February 3, 2015

**RE: Revised Grading Plan (C-18D012)
American Toyota
Albuquerque, New Mexico**

AMERICAN TOYOTA EXPANSION
Albuquerque, New Mexico

DATE: 12/30/14  
DRAWN: WCM  
PROJECT #: 82394  
CHECKED: GFI

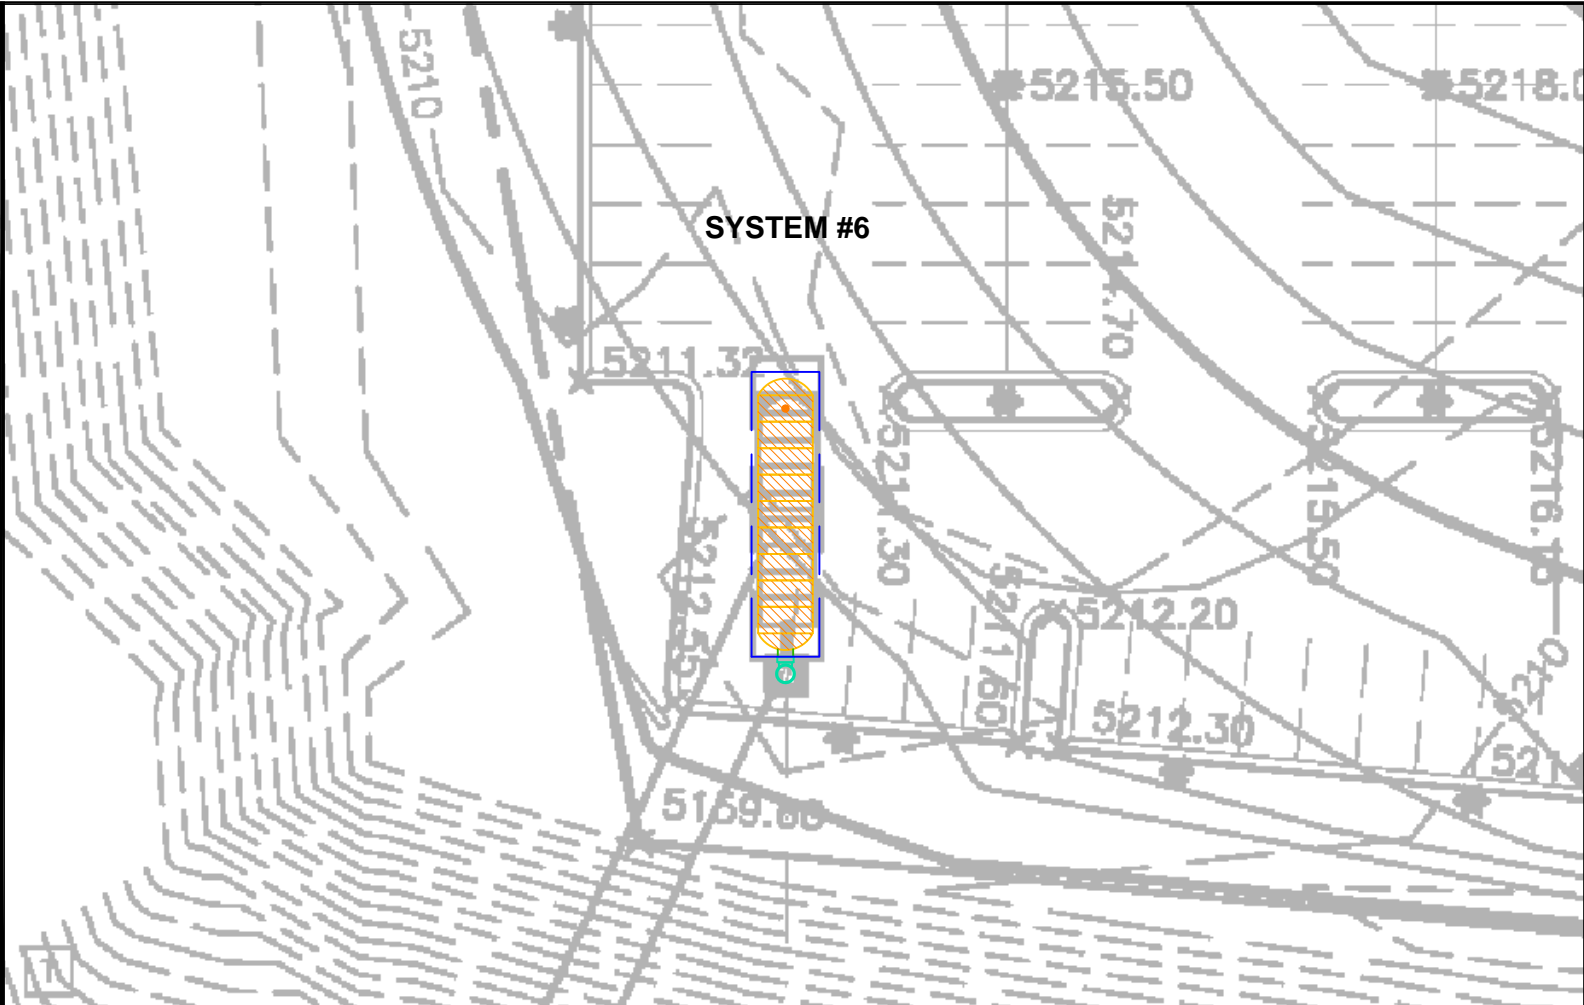
7. Include calculation for the design of the stormtech systems

8. Provide a detail sheet for storm tech system specific to this site

9. How will the storm tech manifold system be done. Provide detail of how to be built

We have included details and calculations for each system,

We have included the details from the manufacturer.

We have included details of system and layout.

ENGINEER'S SEAL	AMERICAN TOYOTA	DRAWN BY WCWJ
 12/2/14	GRADING AND DRAINAGE PLAN	DATE 12-02-14
		21403-LAYOUT-1-25-14
	 <i>Rio Grande Engineering</i> 1806 CENTRAL AVENUE SE SUITE 201 ALBUQUERQUE, NM 87106 (505) 872-0999	SHEET # —
DAVID SOULE P.E. #14522		JOB # 21403

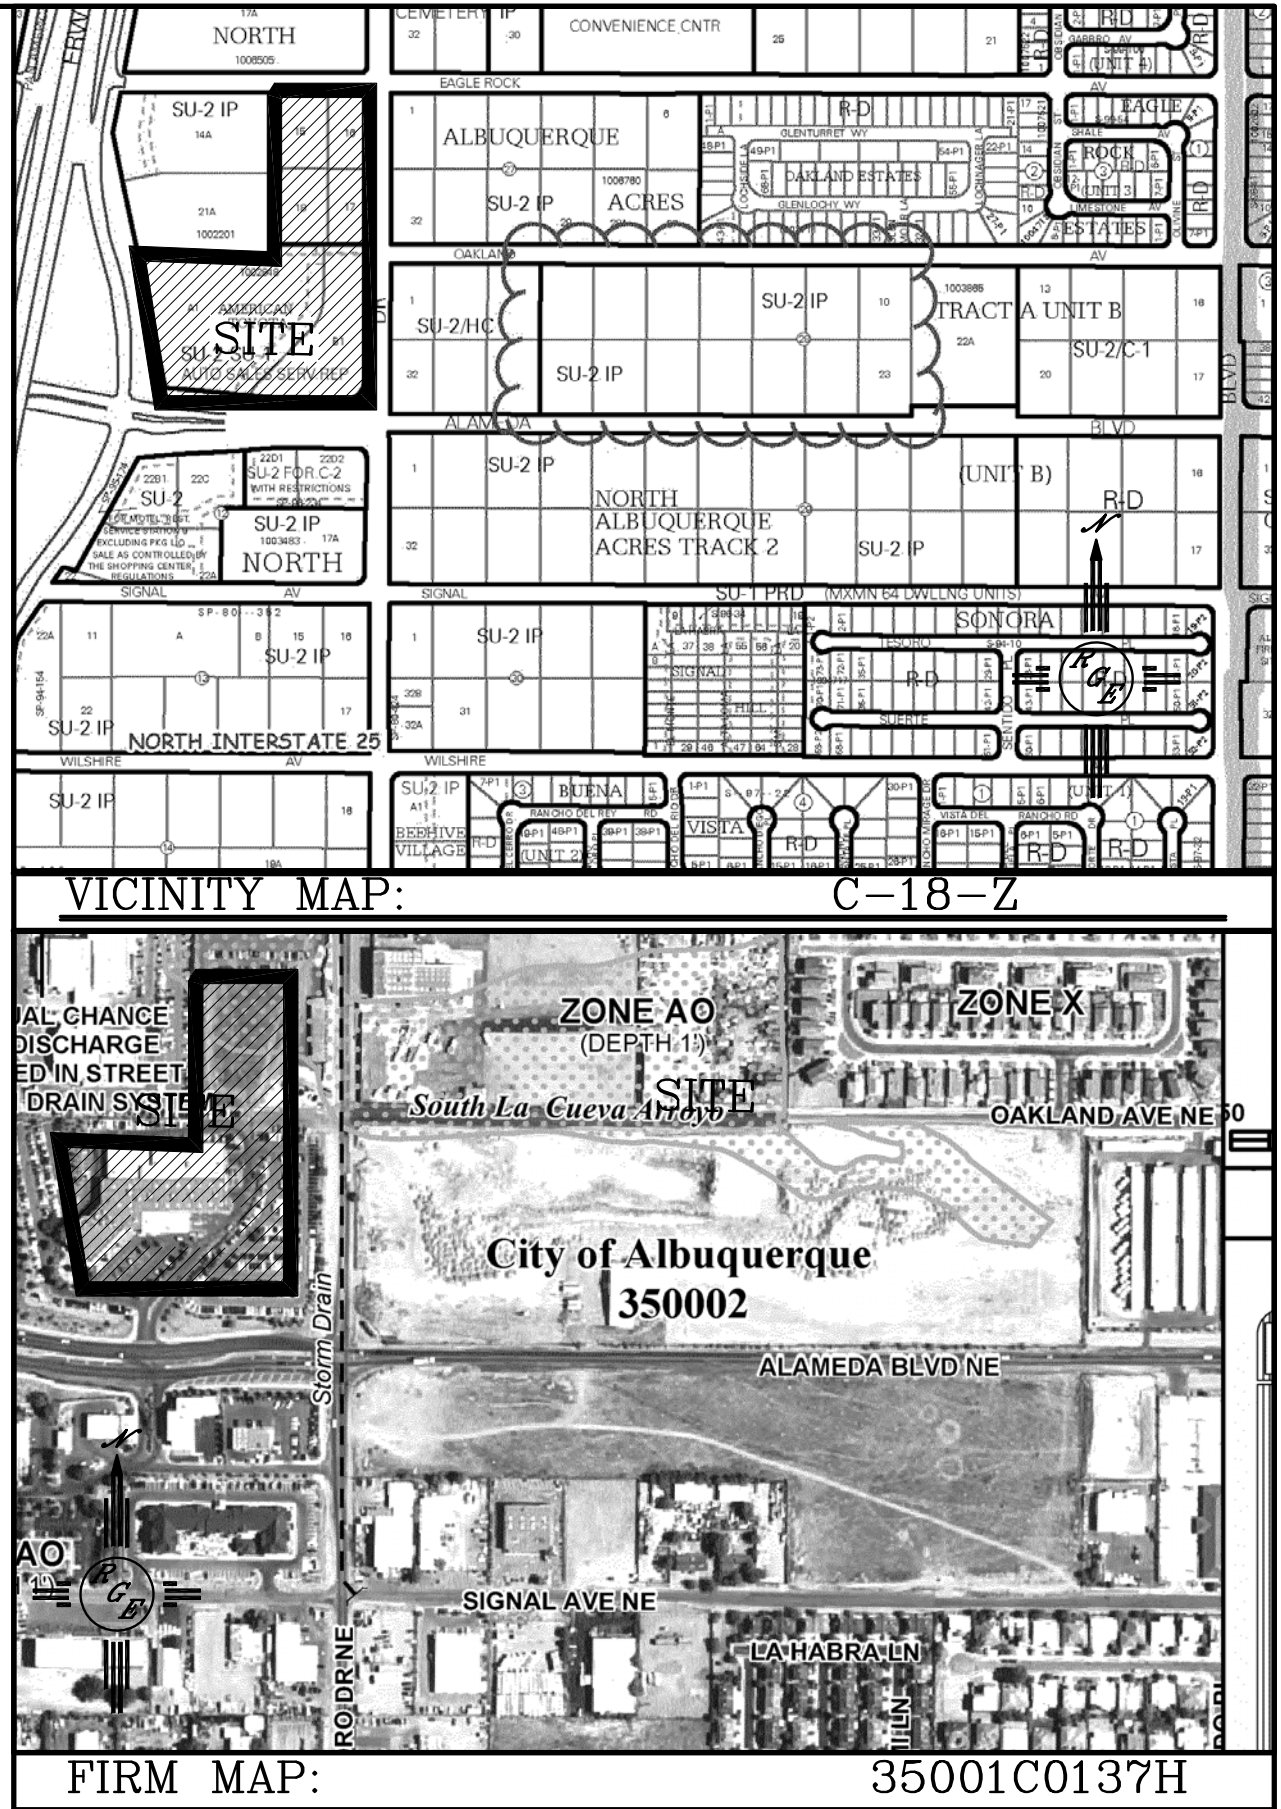
10. In south west corner what is the size of outlet pipe
We have added the size on grading plan
11. In the southwest corner what is size of outlet pip and how will flow go into stormtech and into alameda system
We have added the size of the outlet pipe. The existing pipe will be maintained. A 4' manhole is proposed down stream with a baffle that will force the water into the chambers until they are full then they will discharge to the existing storm drain.

13. In northwest corner what are sizes of pips connection to the system
We have added the sizes of the pipes
14. For north basin will the site no longer utilize existing concrete channel
We will continue to use the concrete channel

17. Show more spot elevations on the wall
We have added additional spots
18. provide electronic copy of report and drawings
We have submitted pdf with this resubmittal
